CITY OF ALBUQUERQUE

December 8, 2023

Re: Home 2 Suites Hotel
3021 Flightway Ave SE
Request for Certificate of Occupancy- 30 Day Temp
Transportation Development Final Inspection
Engineer's Stamp dated 10-26-21 (M15D047)
Certification dated 12-5-23

BIKE RAIL

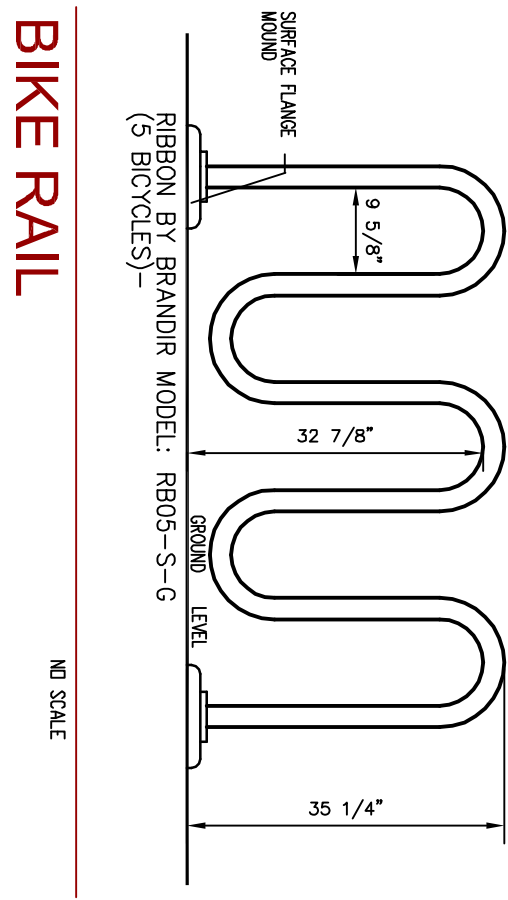
1. The 6' pedestrian pathway to University Blvd is not wide enough. At three locations between the parking lot and the ramp, it was $\leq 46"$ wide between curbs and one location it was 41".
2. Provide five bicycle parking spaces. Currently, there is one wave-style rack, which offers the possibility of providing two bicycle spaces.
3. The approved plan specifies 5 motorcycle parking spaces; however, the IDO only requires 4. Only two were observed on the east side of the building. Provide 4 motorcycle parking spaces.
4. The ramp north of the accessible parking aisle had an average longitudinal slope of 11.6%; which is steeper than the maximum of 8.3%. The ramp should be replaced with a ramp with an acceptable longitudinal slope.
5. A "No Parking" pavement marking is required at the back end of the accessible parking aisles. See image on next page.

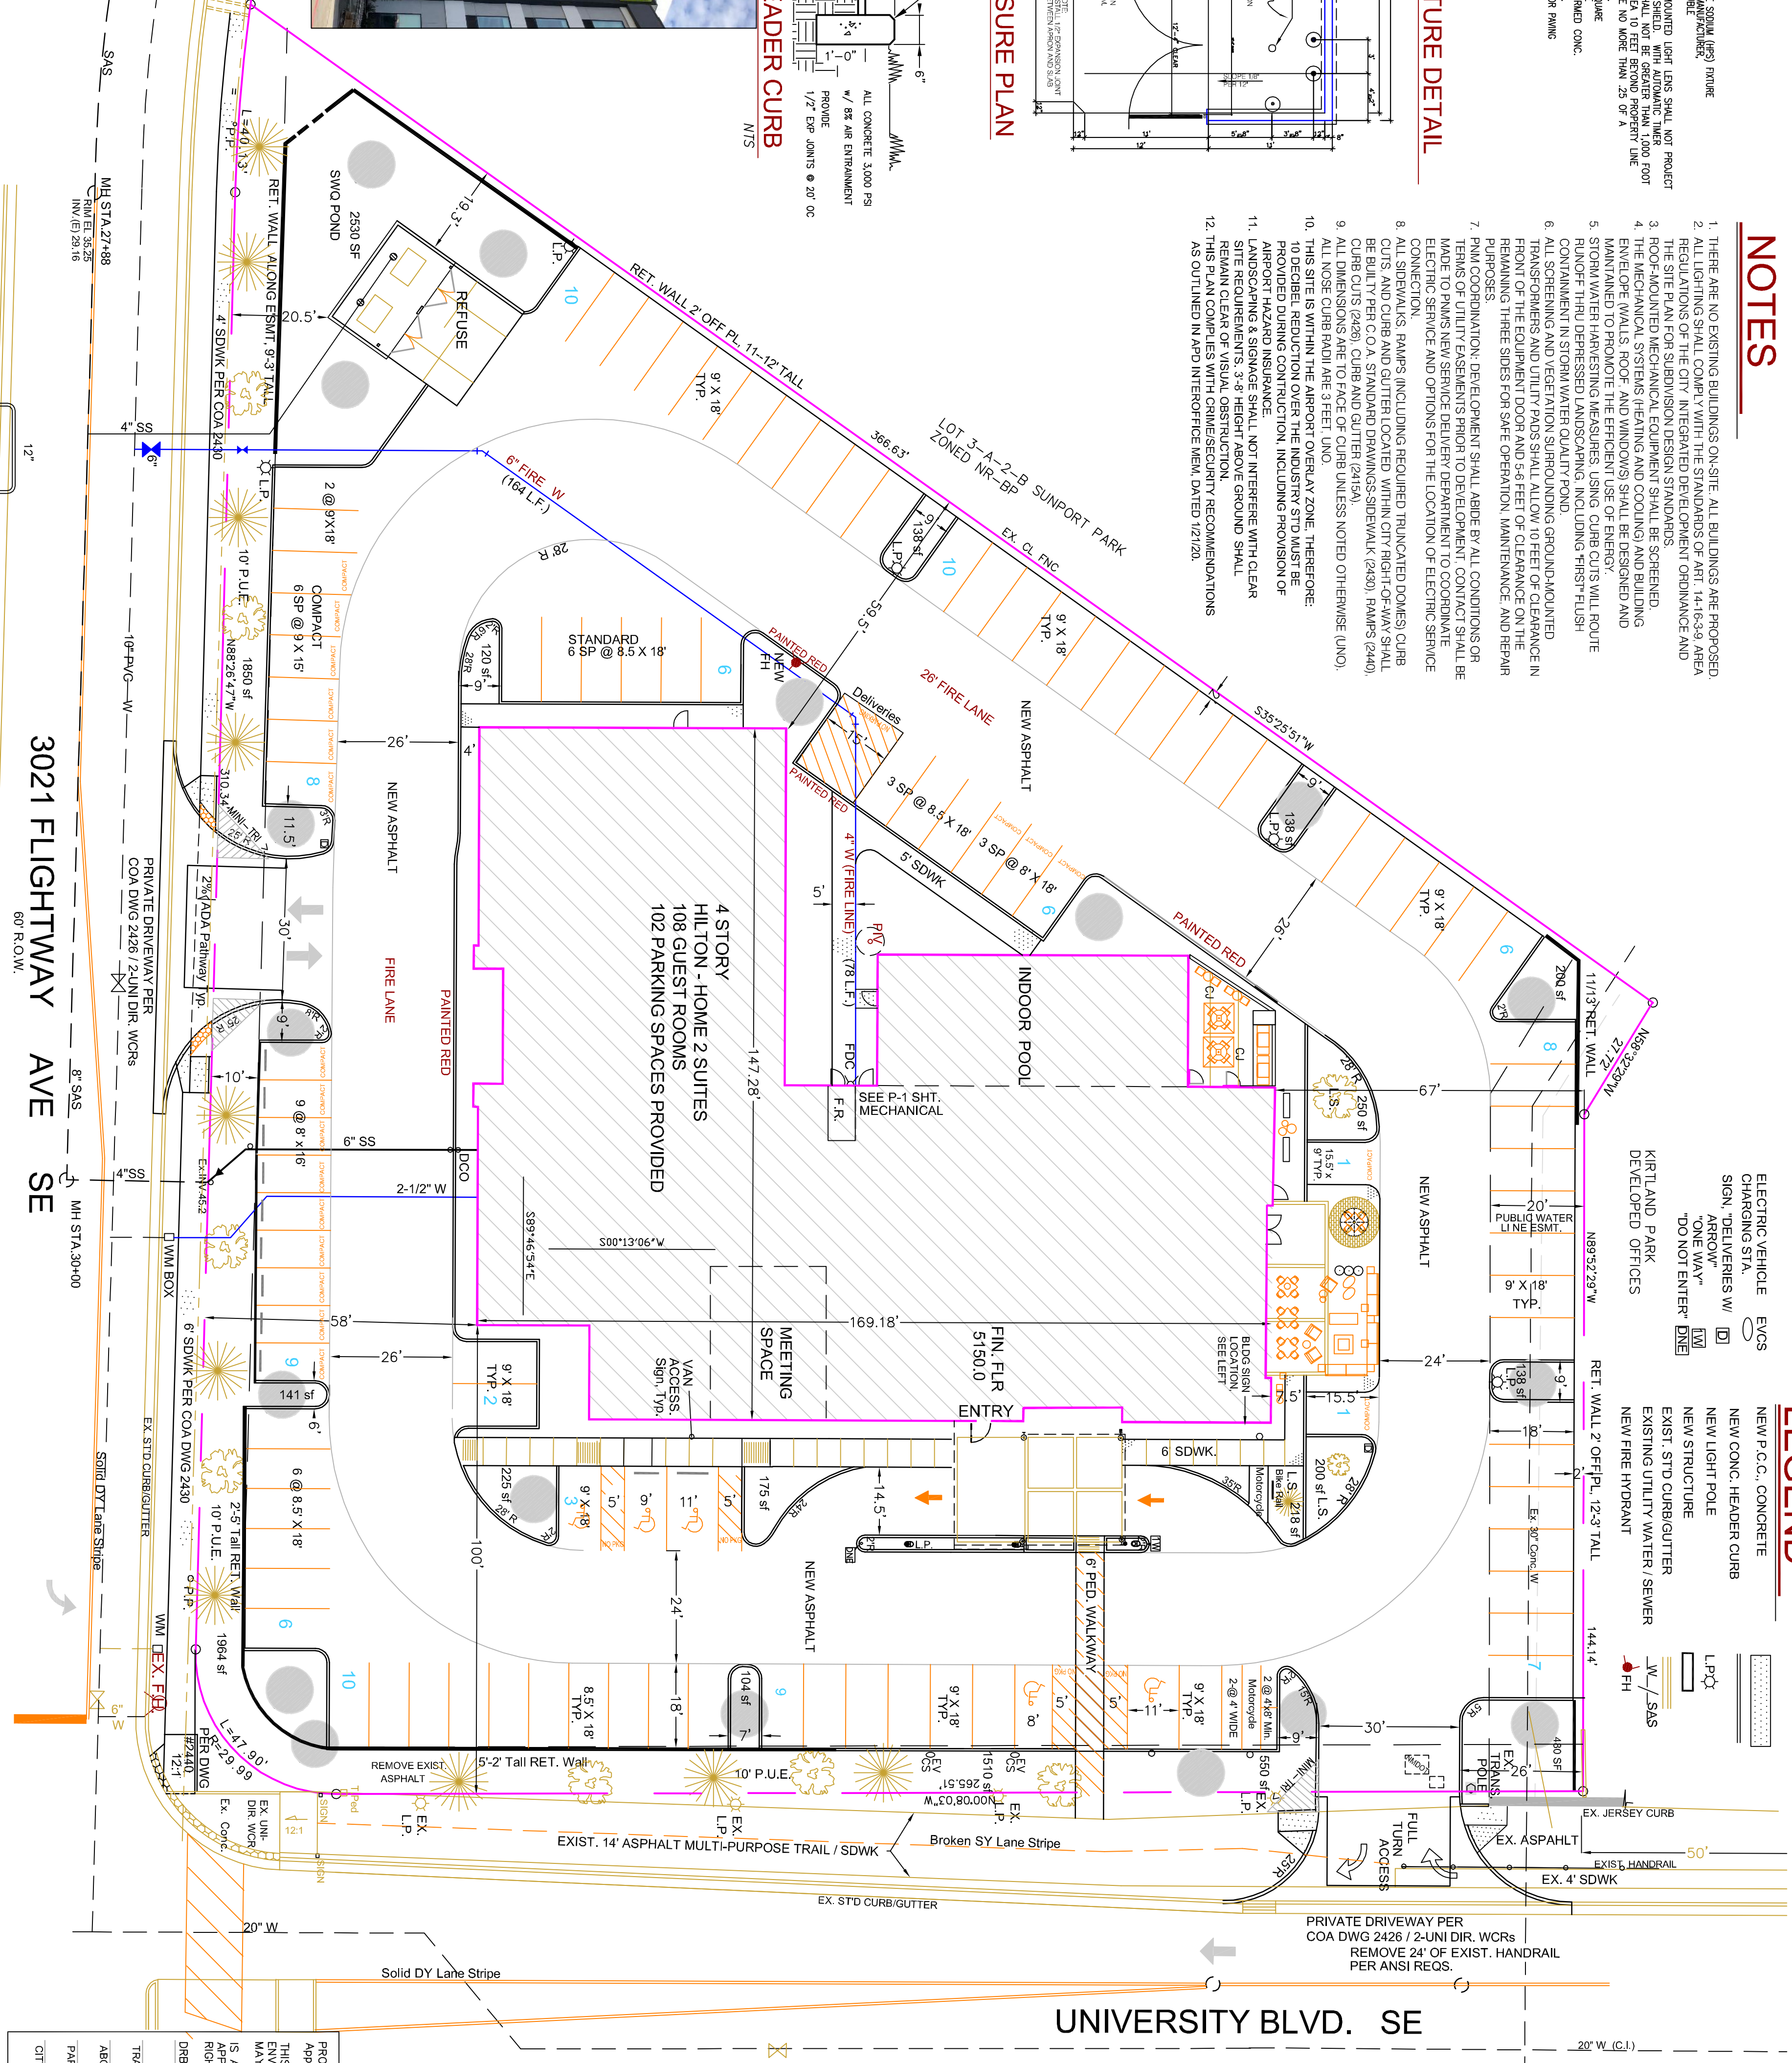
6. The Accessible Parking signs do not include the required language: "Violators are subject to a fine and/or Towing."
